From: Geoff Thorpe [REDACTED]
Sent: 27 June 2019 10:59
To: Planning
Subject: Applications AB/48/19/PL and AB/49/19/L - for the attention of Mrs Gardner

terrier firma

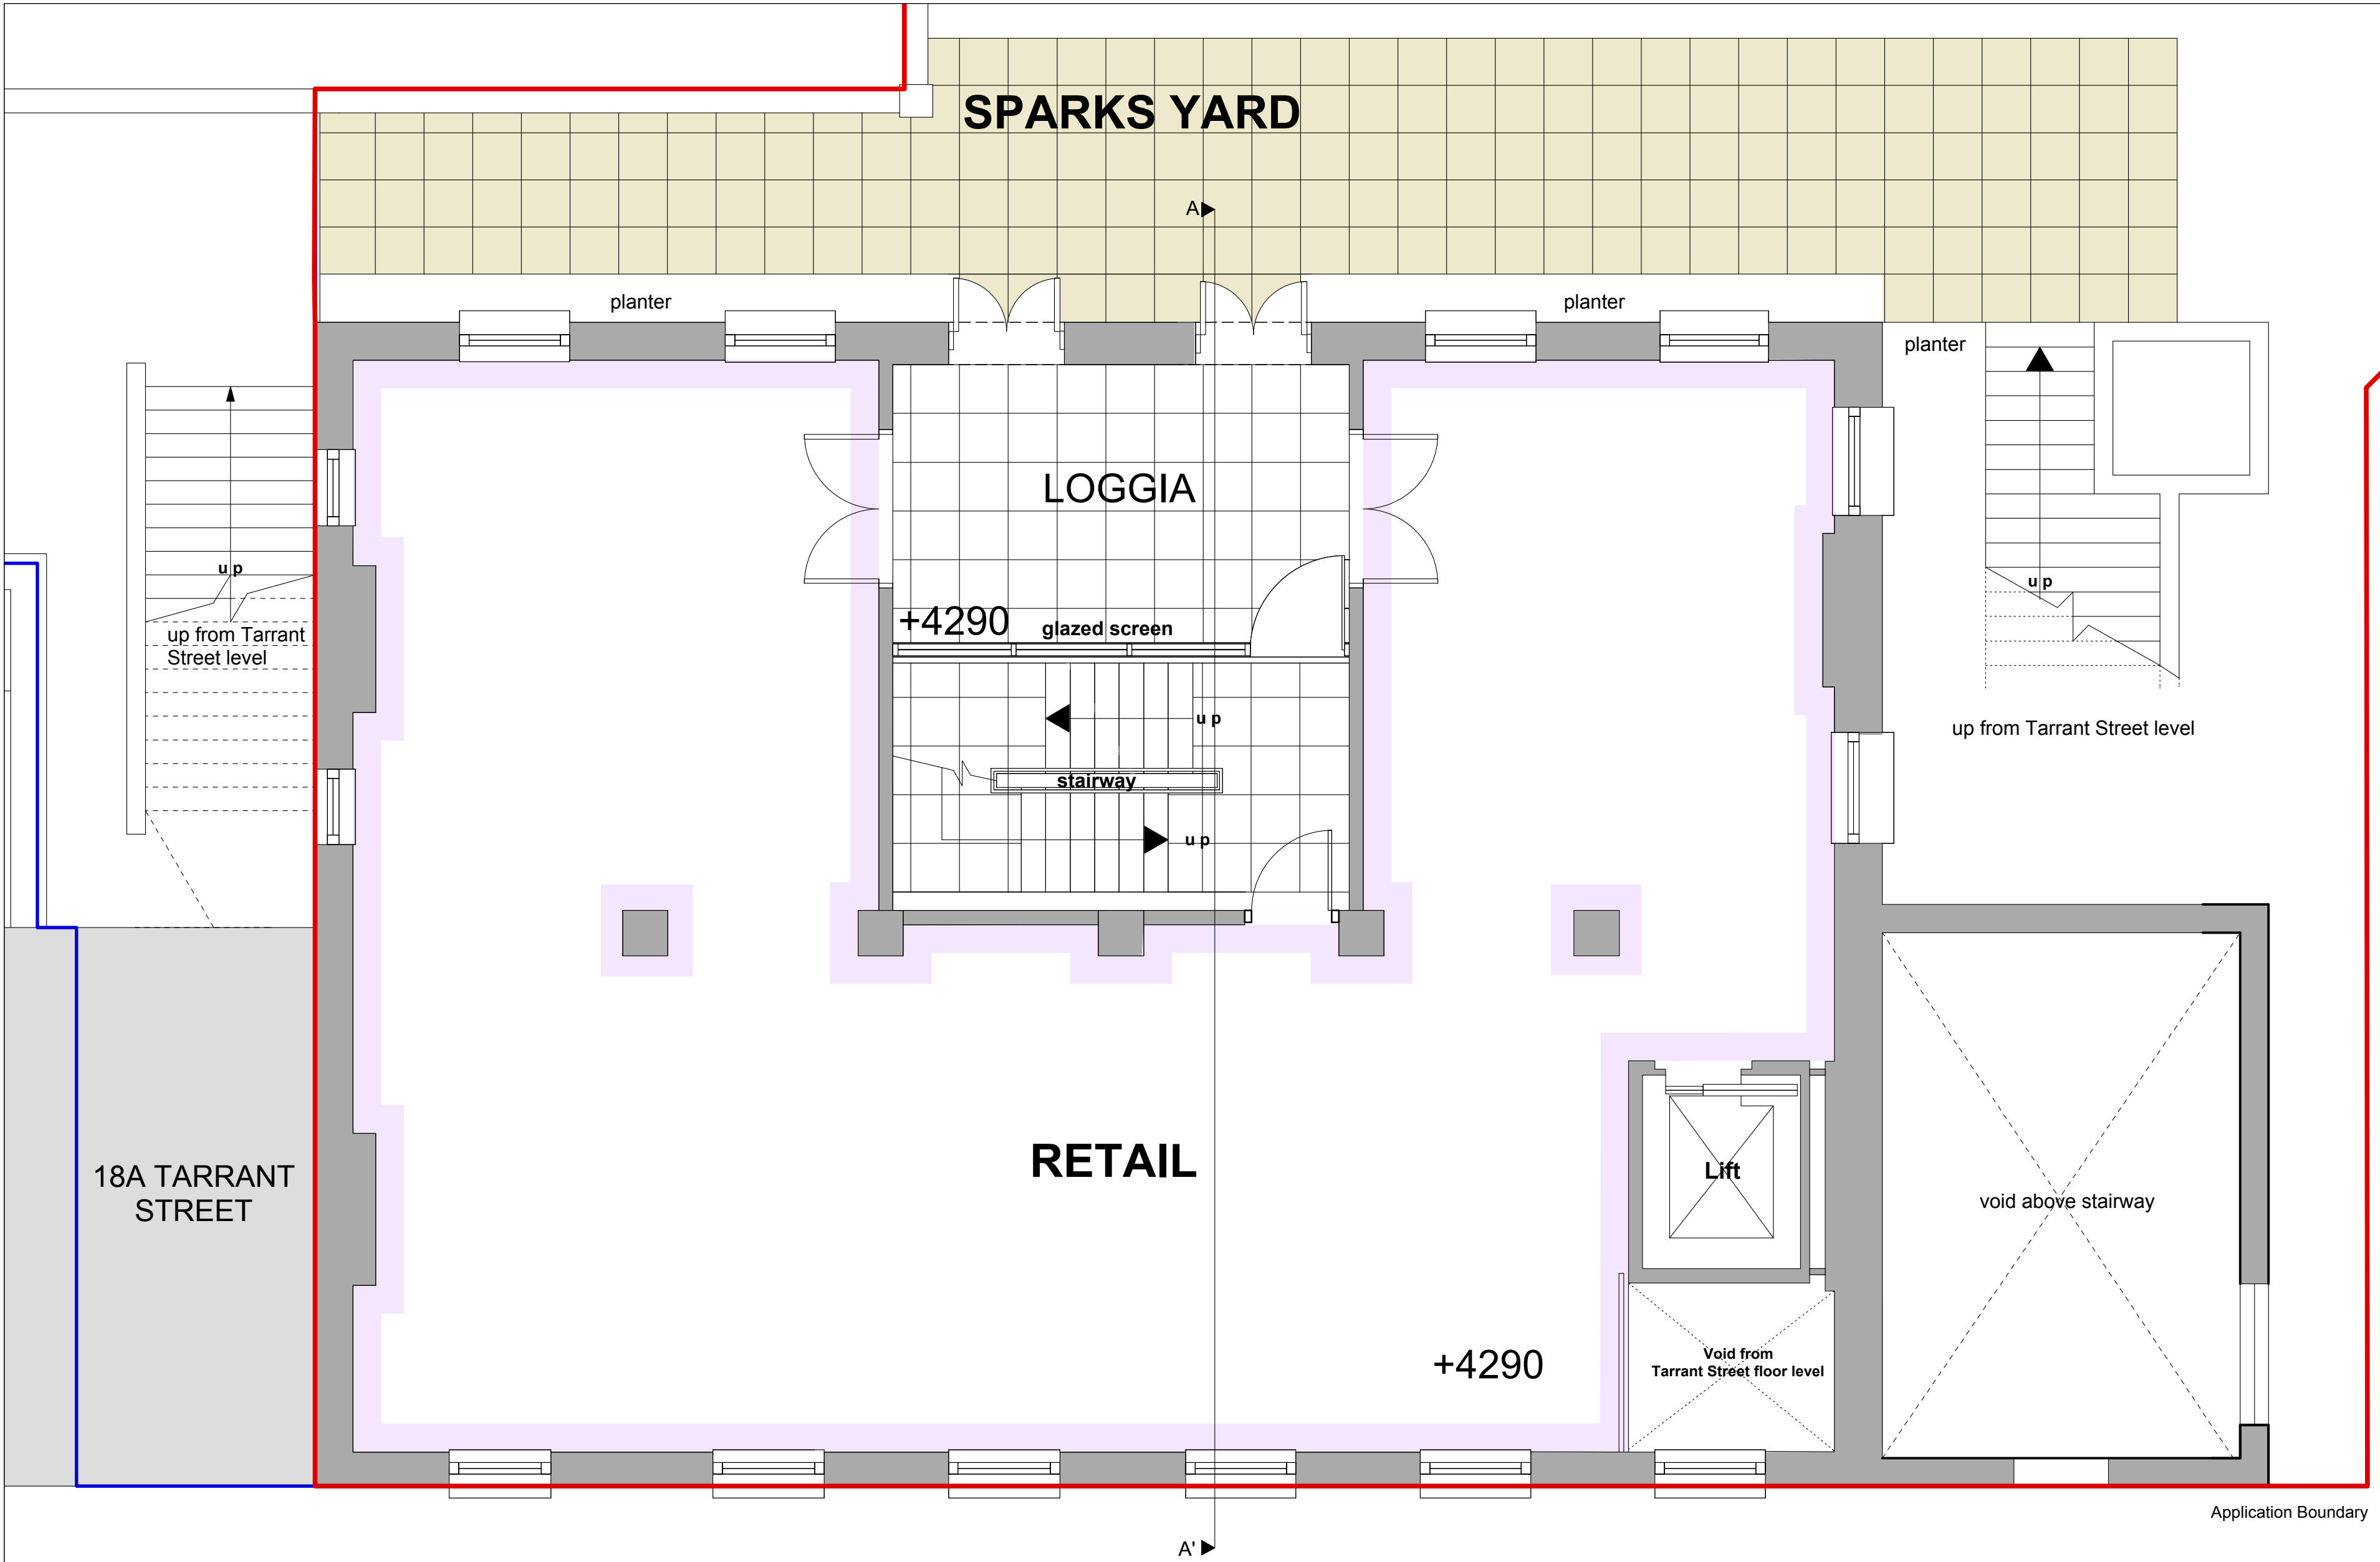
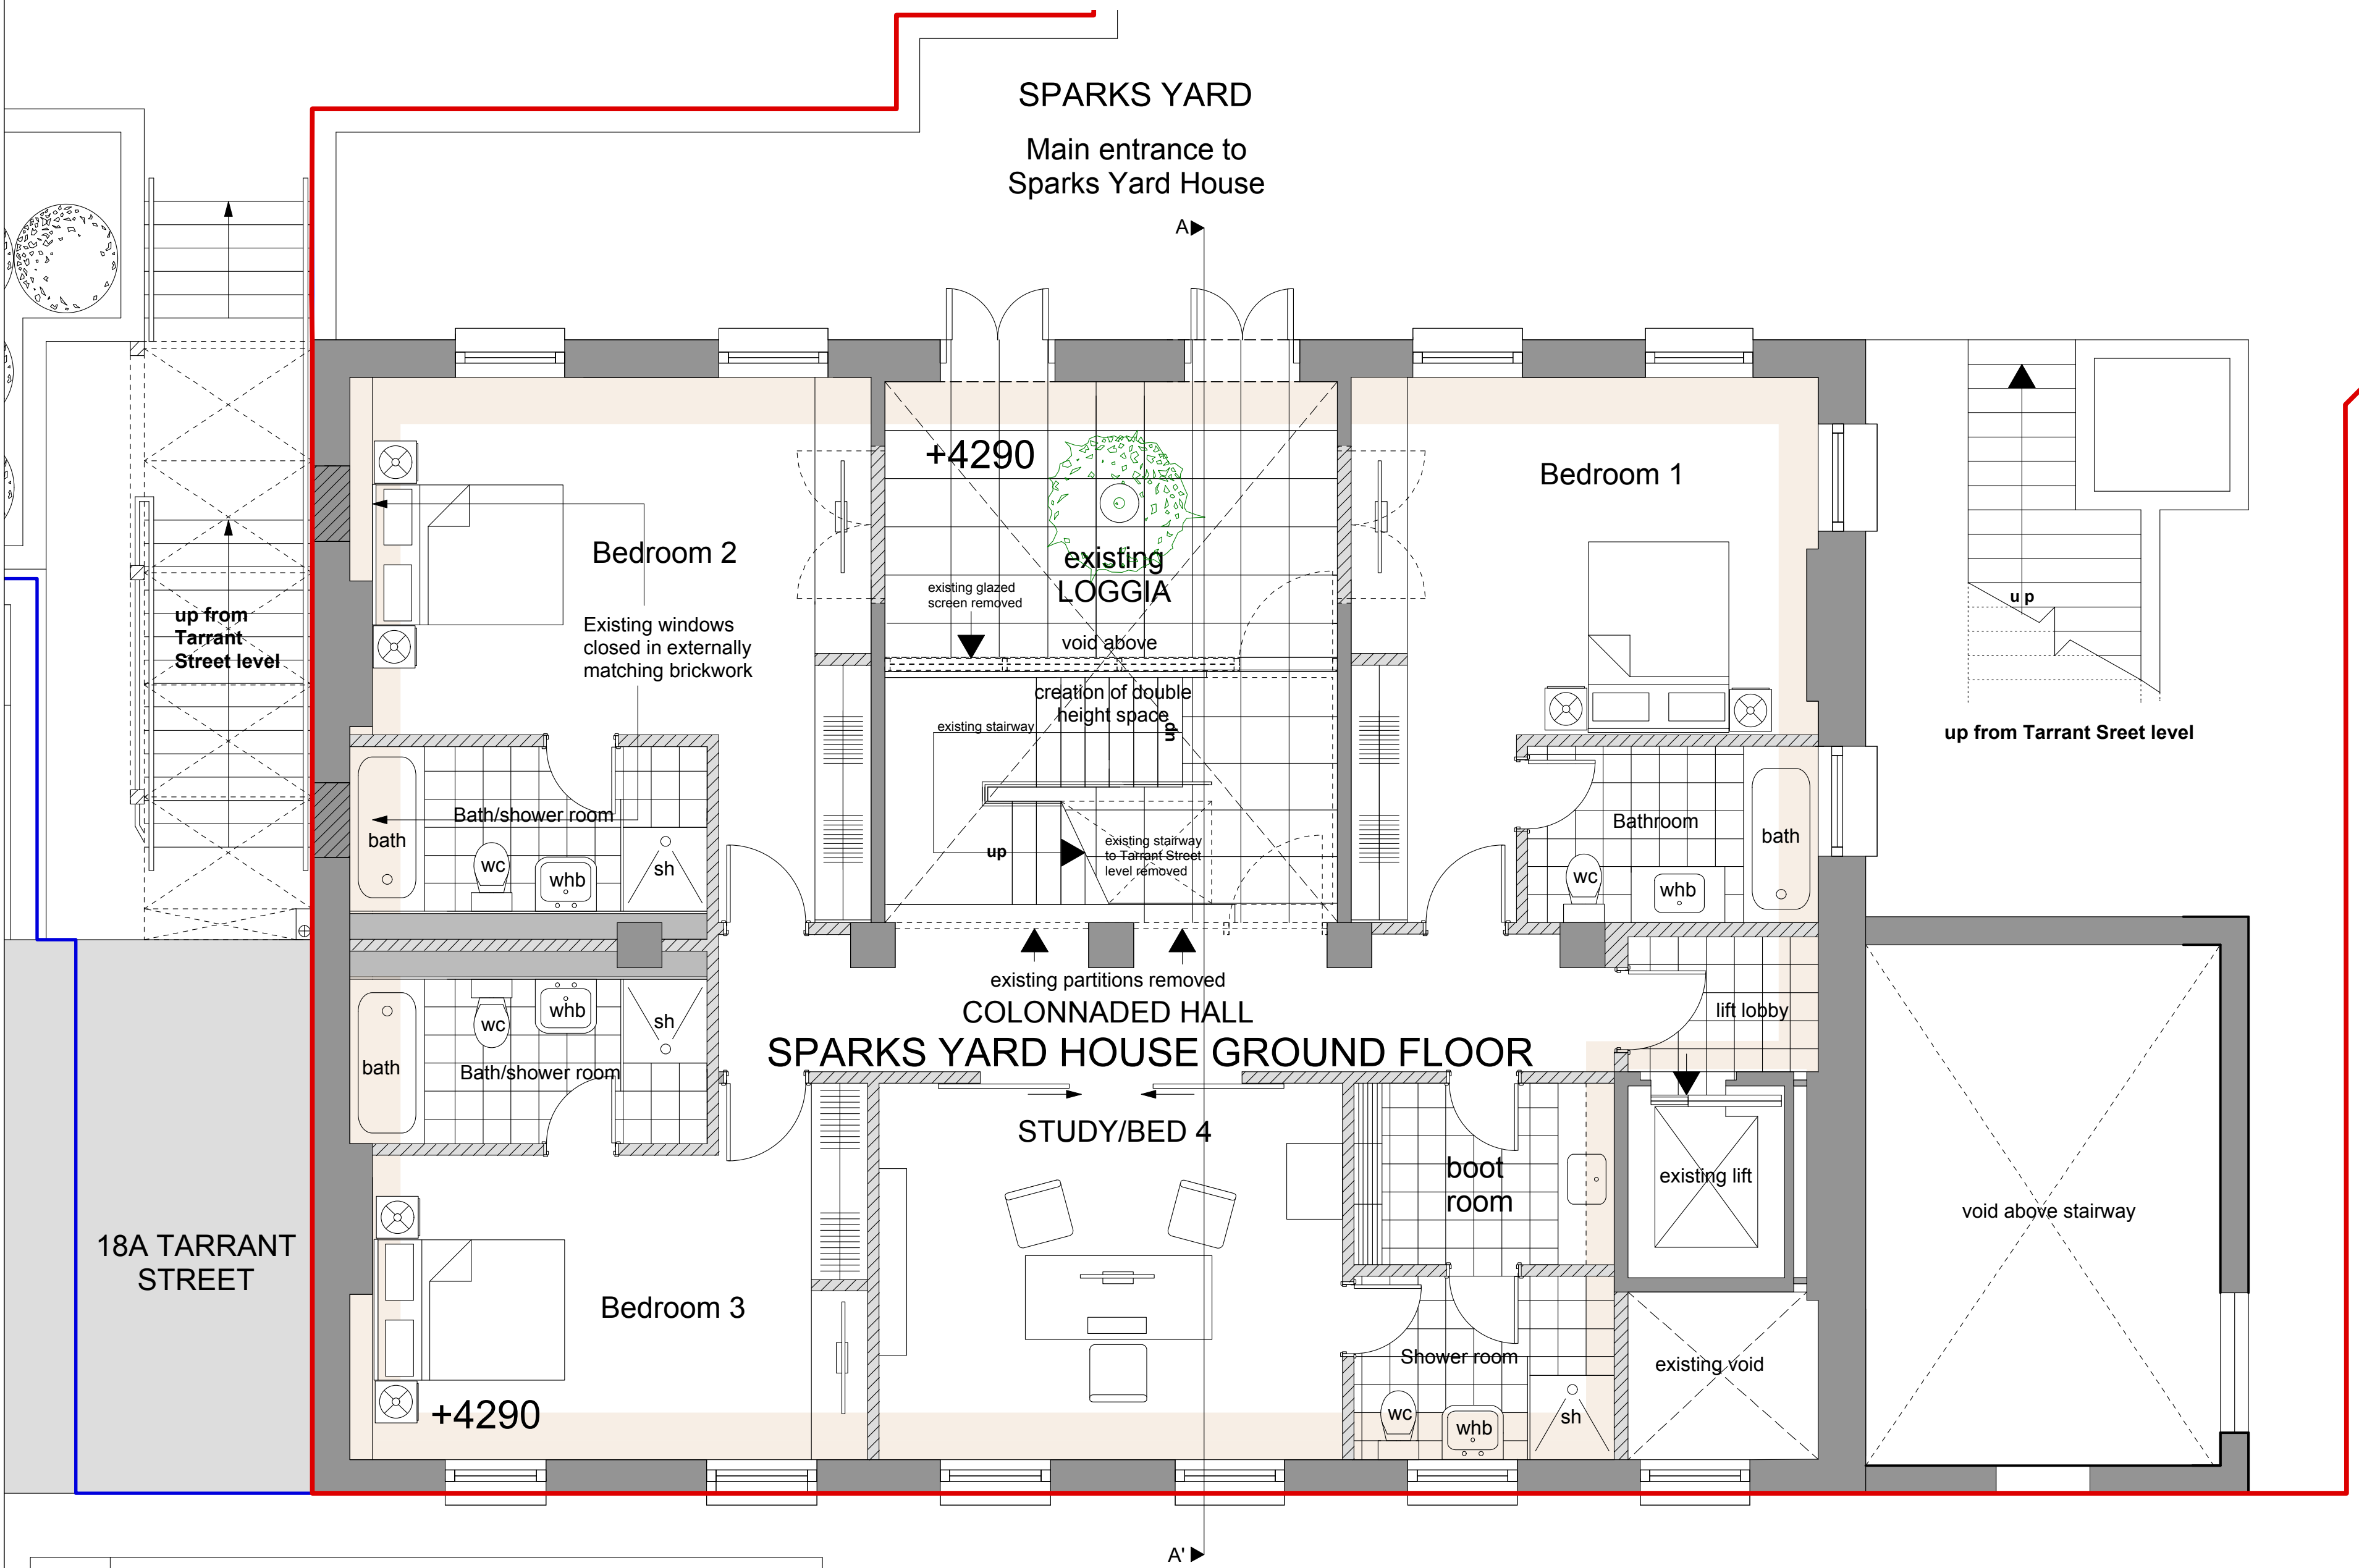
2. I am delighted to read the concerns relating to the lining of the external brick walls with insulation and plasterboard. We do not wish to do this and it was only included in the proposal in order to satisfy the inevitable thermal insulation requirements of building regulation approval. I confirm therefore that we wish to amend our applications in order to remove all proposed external wall linings to the upper two floors of the buildings and will seek an agreement to relaxation when the building regulation approval

application is made, citing its unacceptability for inclusion within this listed building. Would you like us to submit amended drawings to cover this or can this be covered by a potential condition?
